Planning Inspectorate

East Midlands Gateway phase 2 – BC0410001

Section 51 advice regarding draft application documents

Issued on 01 April 2025

Figure 1: Site Location, River Mease & Mease Rivers Operational Catchment

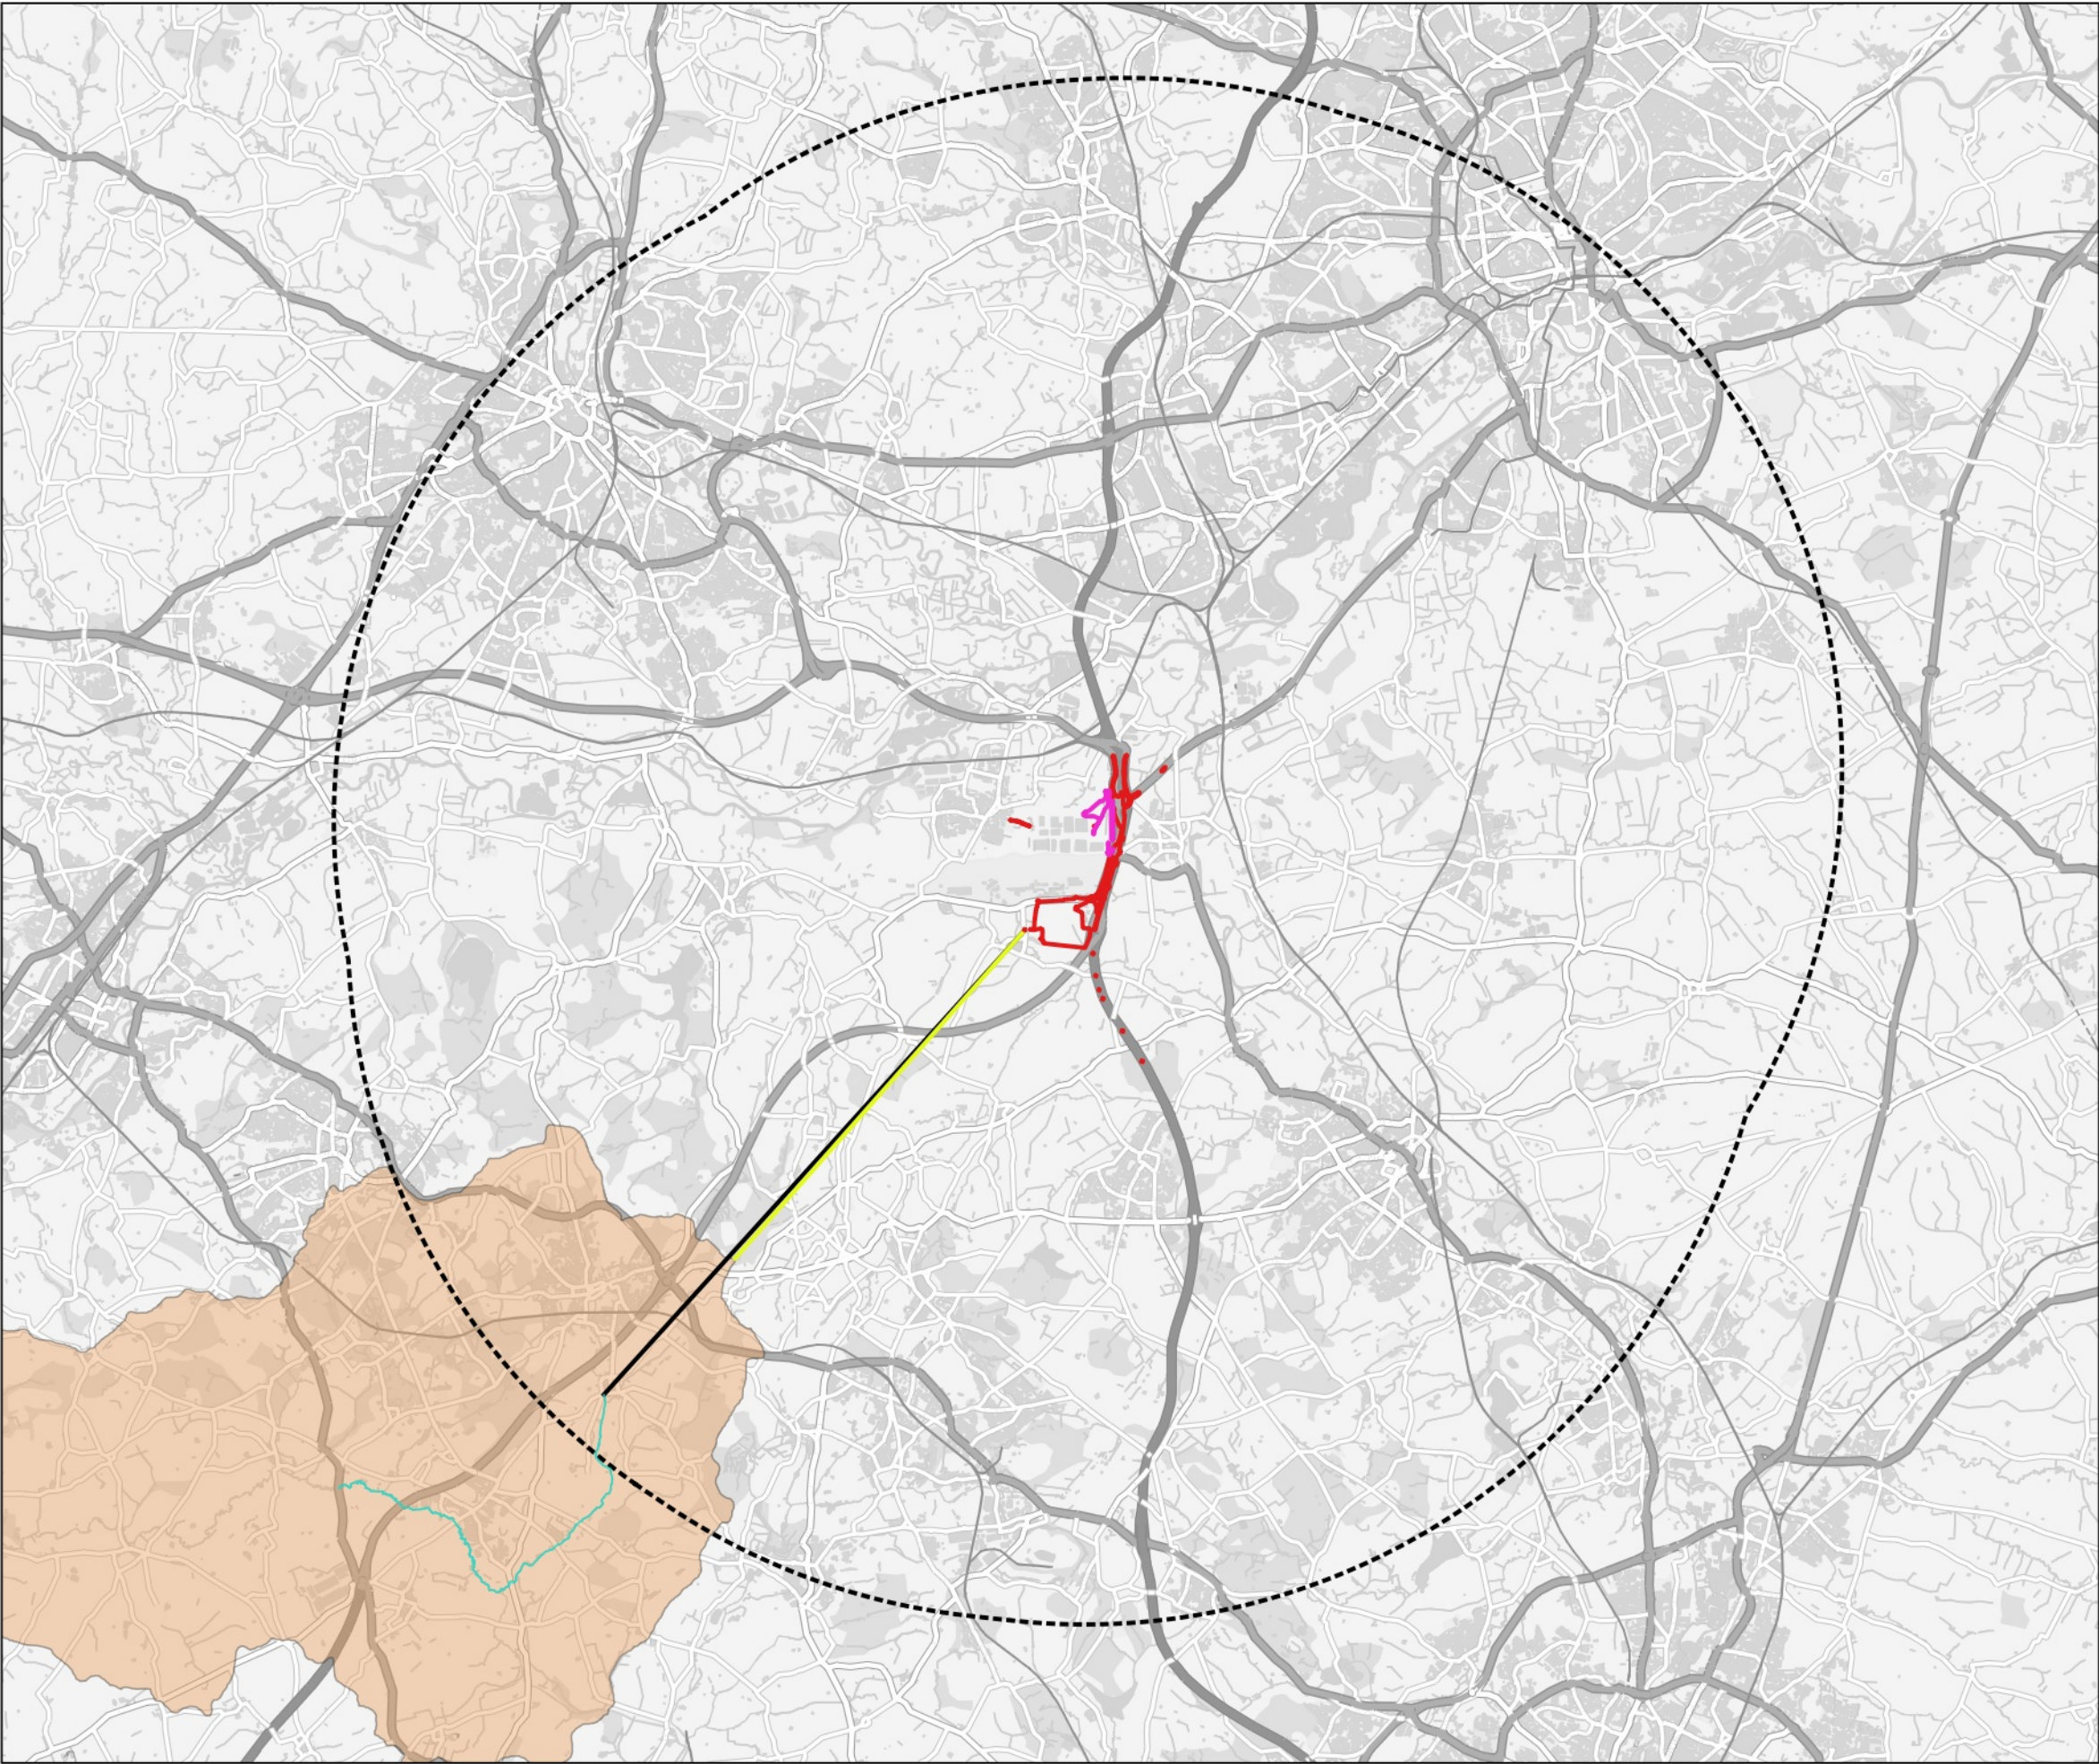
3.	Figure 1	With reference to ID 2 above, Figure 1 is not consistent with the plans supplied as draft works plans and draft land plans in that it appears to show work associated with the material change / DCO application as well as the dDCO but this is not set out in the way the document is structured. The HRA report should therefore be clear whether it is intended to support both applications and if so, the plans amended to demonstrate this.
